To Protect and Promote the Health and the Environment of the People of Kittitas County

To: All Staff
From: Environmental Health
Date: 7/27/2026
Subject: AU-16-00008

SHEET TITLE:
SITE PLAN / COVER

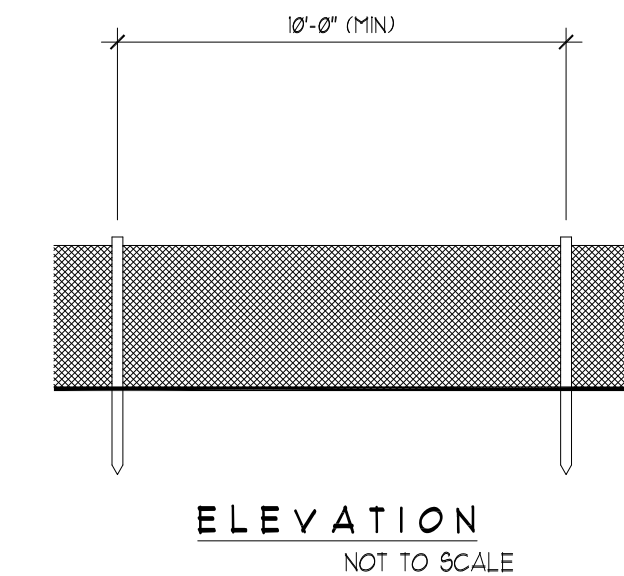
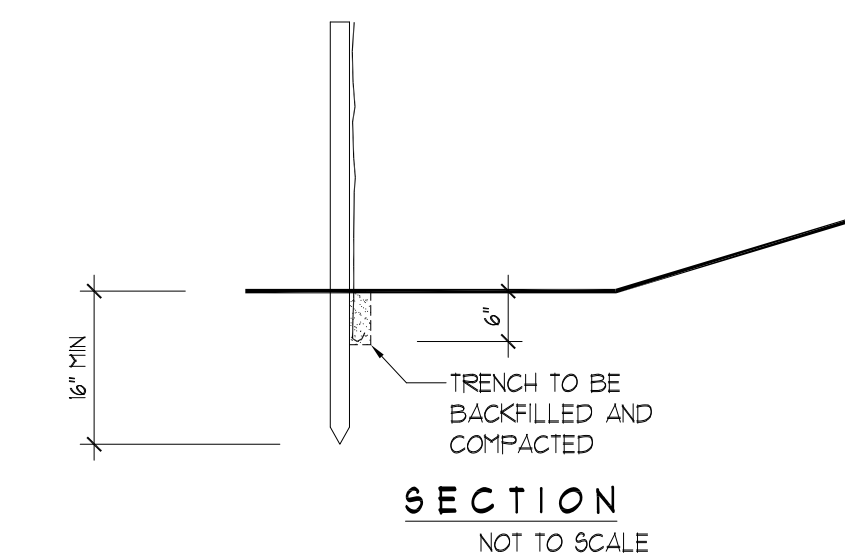
Drinking Water	• Since there is already an existing well with one dwelling unit connected, an AWSO I/S is necessary for the project due to two dwelling units connecting to the well.
Wastewater	• If the existing septic system is going to be used for the new SFR a new connection permit application will need to be submitted with a design showing how the new SFR is going to connect to the existing septic. The homeowner or a licensed OSS designer can create the design. A final inspection of the connection will also be needed. • If the new SFR is NOT going to connect to the existing septic system, then a site evaluation followed by a design by a licensed OSS designer, or homeowner, will need to be submitted. A final inspection will be needed as well.
